Rezoning Transportation Analysis

Petition Number: 2021-193

General Location Identifier: 20120110

GRAHAM PARK INDUSTRIAL
 REZONING PETITION NUMBER 2021-193
 CHARLOTTE, NORTH CAROLINA
 GRAHAM PARK, LLC
DEVELOPMENT STANDARDS

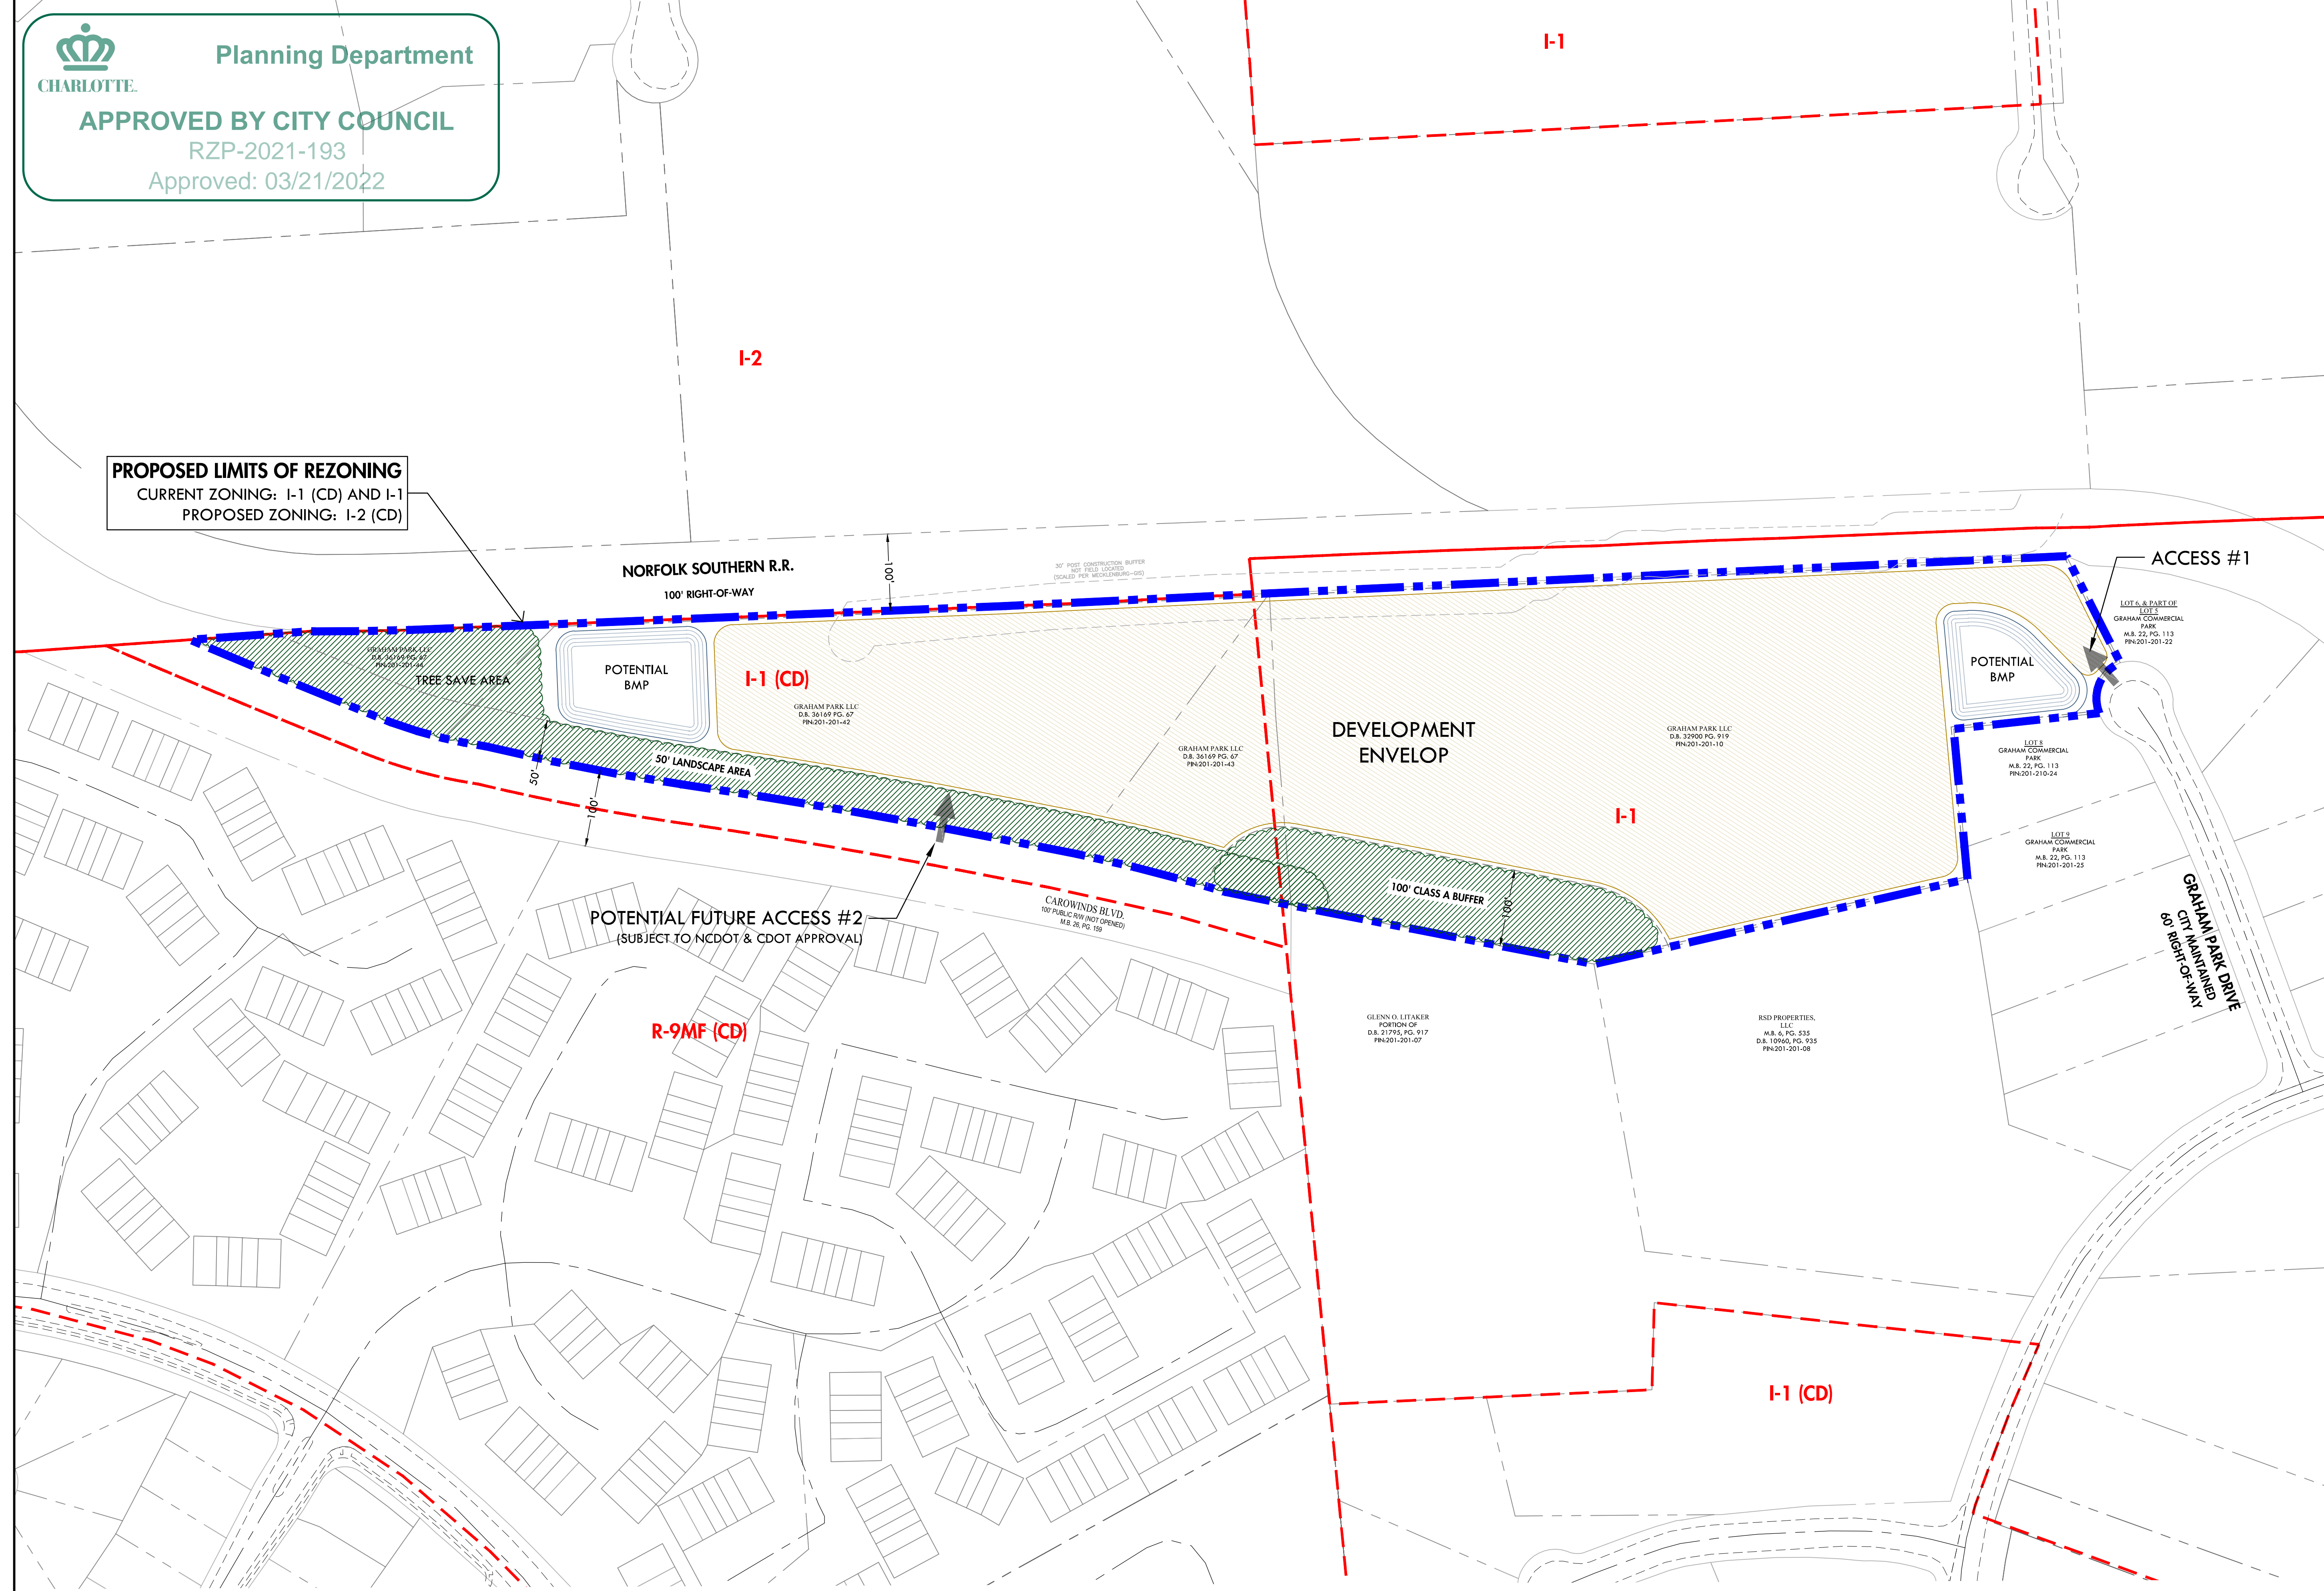
2. Revise conditional note 4.C to:

“At such time as NCDOT STIP# U-6168 (Carowinds Boulevard Extension) is constructed, the petitioner may coordinate with NCDOT and CDOT to construct a single driveway connection, as means for secondary site access. This driveway will be subject to NCDOT and CDOT approval.”

Update to Comment as a result of 01-17-2022 Site Plan: Revise conditional note 4.C to the following:
 “At such time as NCDOT STIP# U-6168 (Carowinds Boulevard Extension) is constructed, the petitioner may coordinate with NCDOT and CDOT to construct a single driveway connection, as means for secondary site access. This driveway will be subject to NCDOT and CDOT approval.”
